22 July 2020

**Supplementary Response to Submissions
Multi-Trades and Digital Technology Hub, TAFE NSW Meadowbank Campus, Meadowbank
Education and Employment Precinct (SSD 10349)**

Further Project Amendments

DWG #	DA20	REV	E
SCALE @ A1	As indicated

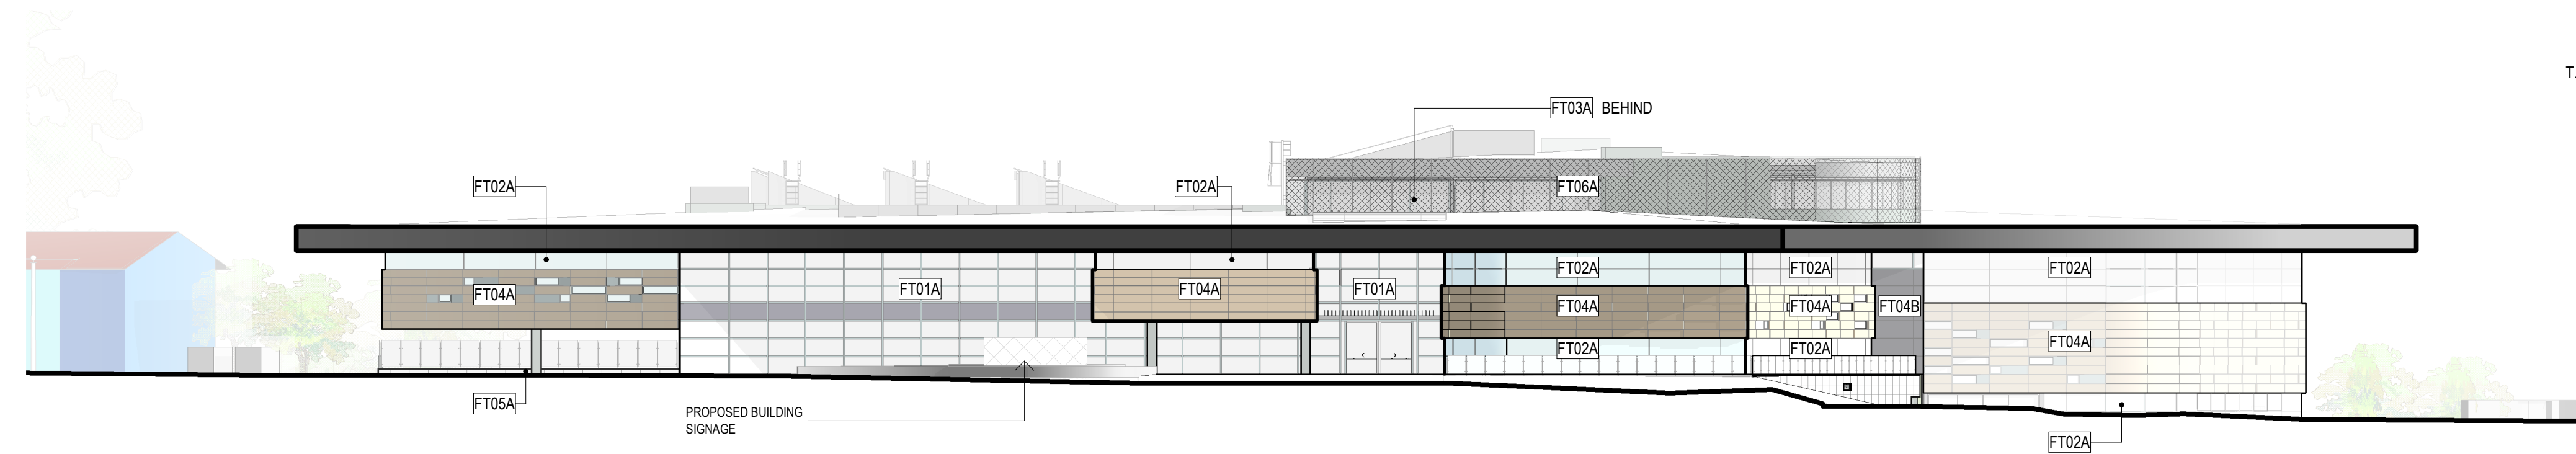
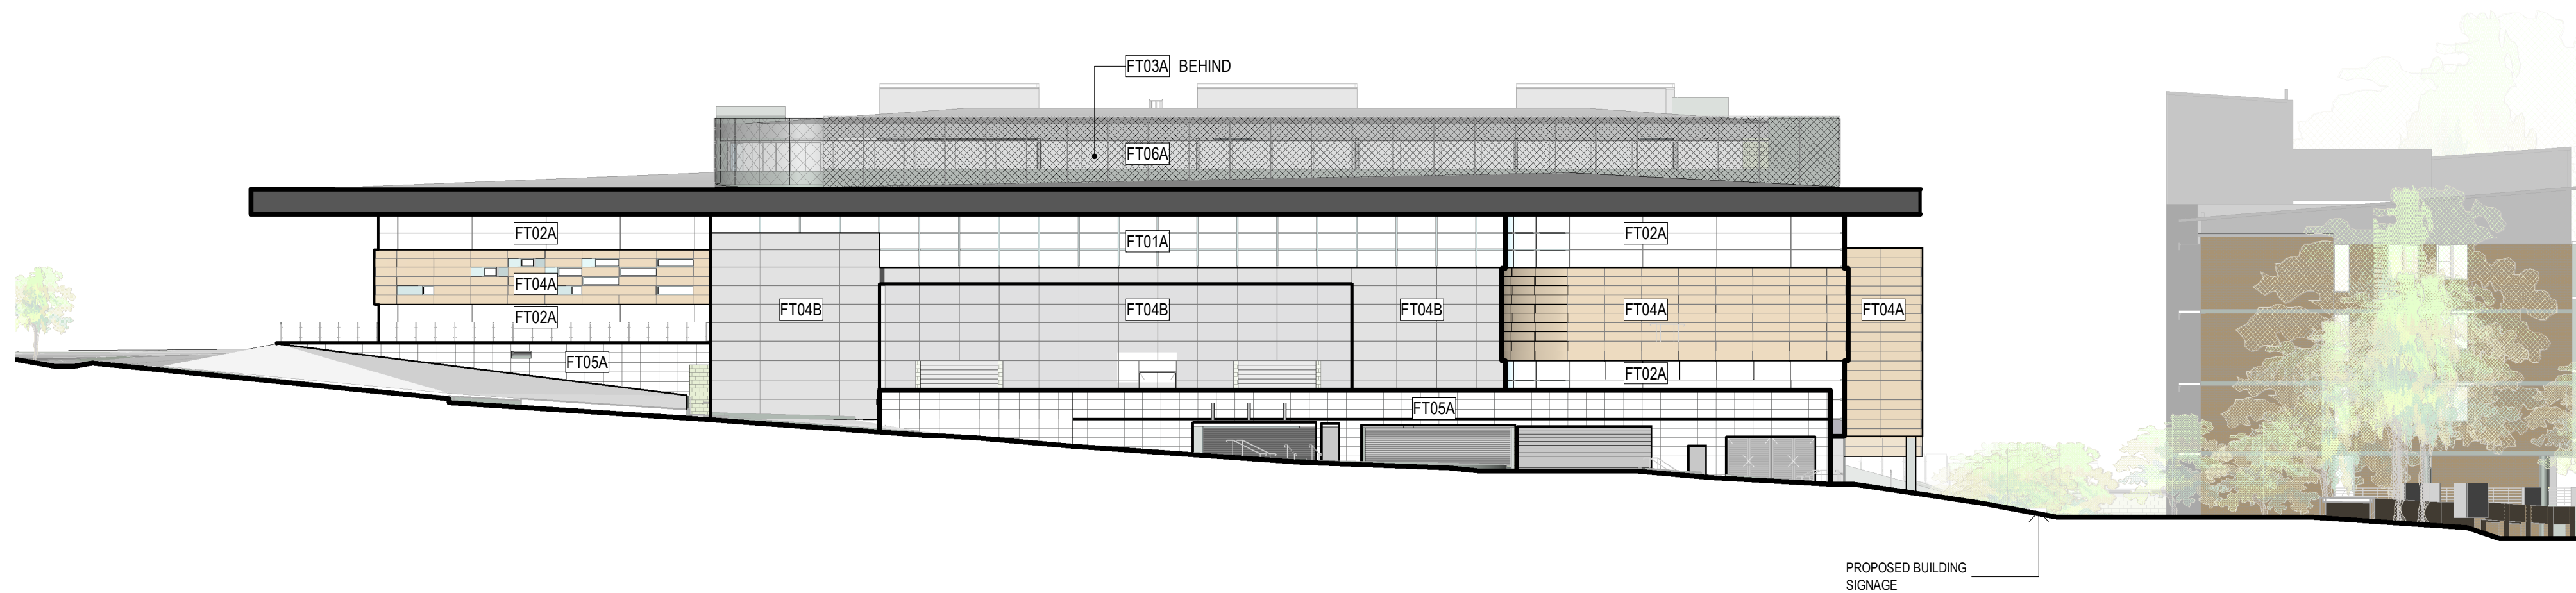
Building Height

The building height of the Hub is to be reduced slightly when compared to the original SSD application.

This is achieved by lowering the original floor to floor height across levels 1-2, 2-3, 4-5, 5-6 and Level 6 Roof as detailed below:

Level	Original SSD RL	Adjusted RTS RL	Change
One	+13.470	+13.870	+400mm
Two	+17.870	+17.670	-200mm
Three	+21.470	+21.470	0
Four	+25.470	+25.470	0
Five	+29.470	+29.270	-200mm
Six	+33.470	+33.070	-400mm
Top Of Skylight	+40.850	+40.800	-50mm

DWG #	DA21	REV	E
SCALE @ A1	As indicated

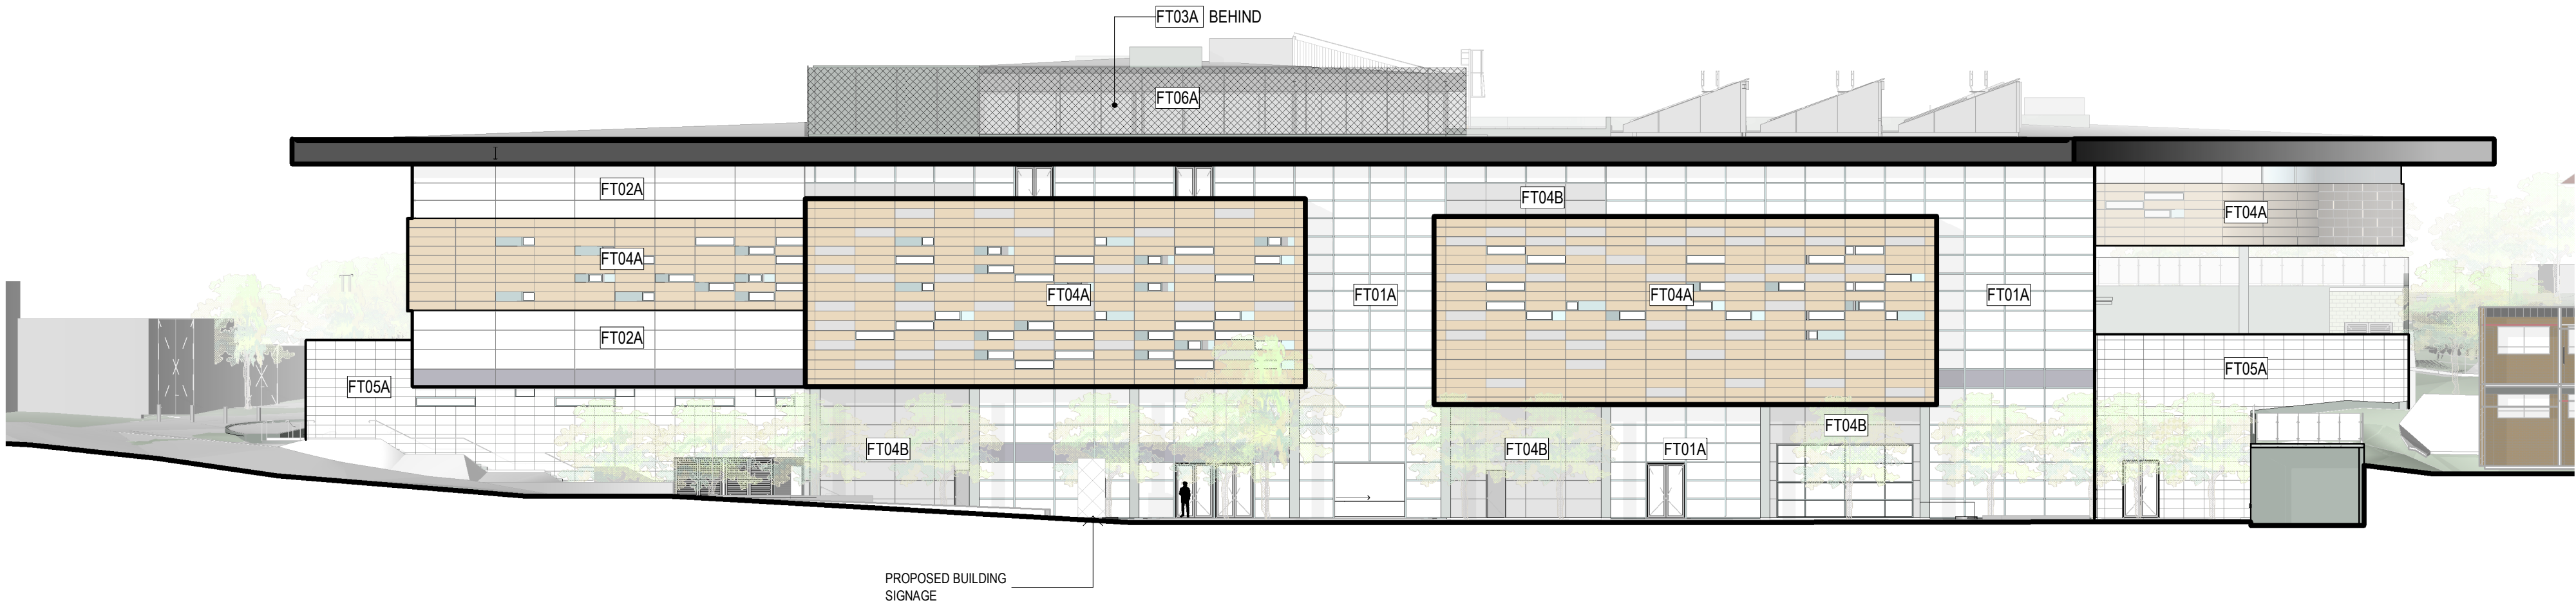
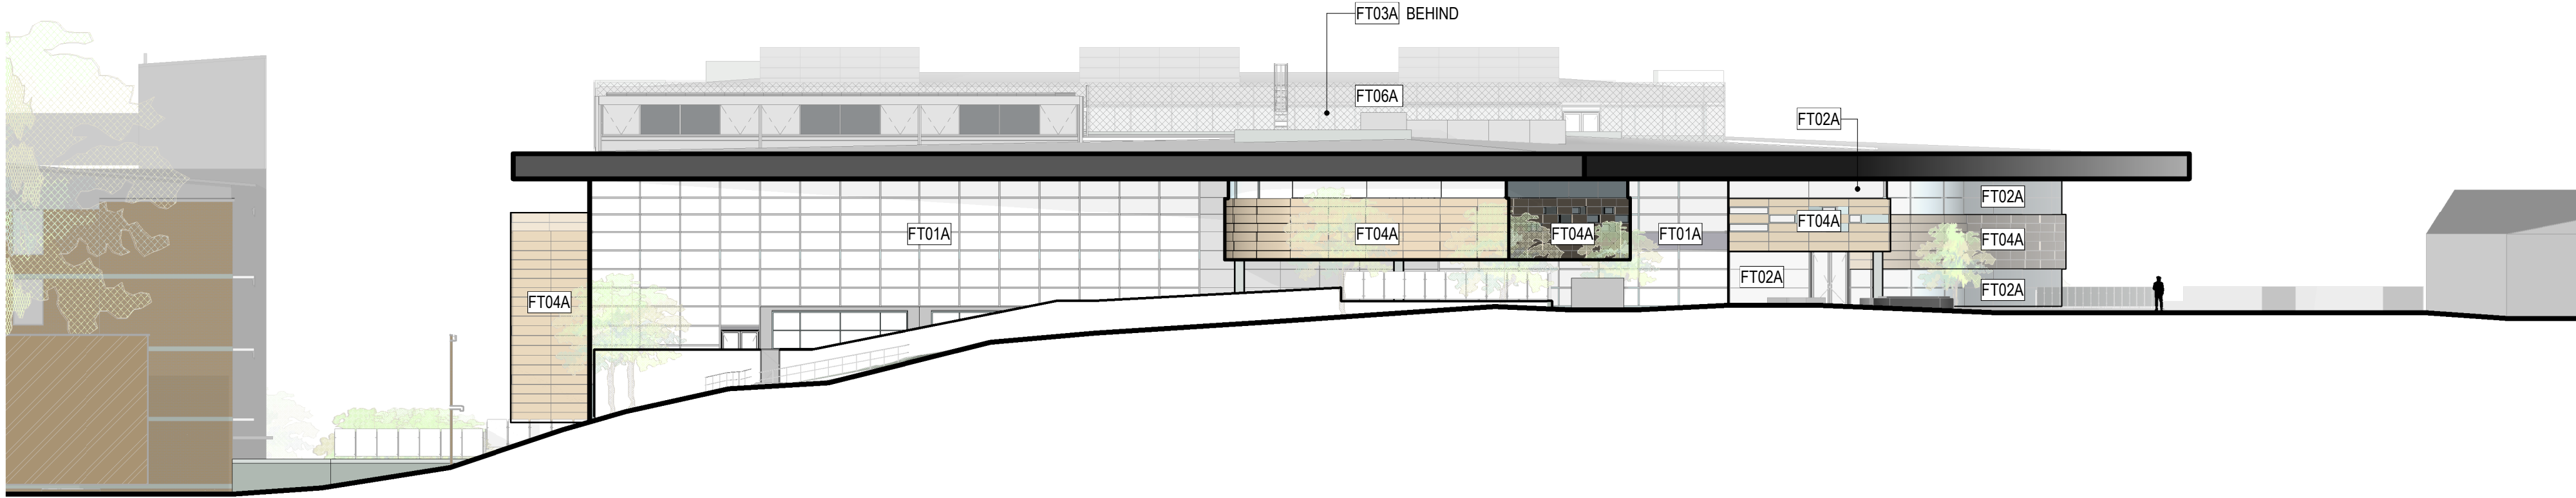
Reduced Glazing to The Hub Facades

The extent of glazing for sections of the Hub is reduced and replaced by solid façade in the form of cladding. This approach is primarily utilised around fire stair sections.
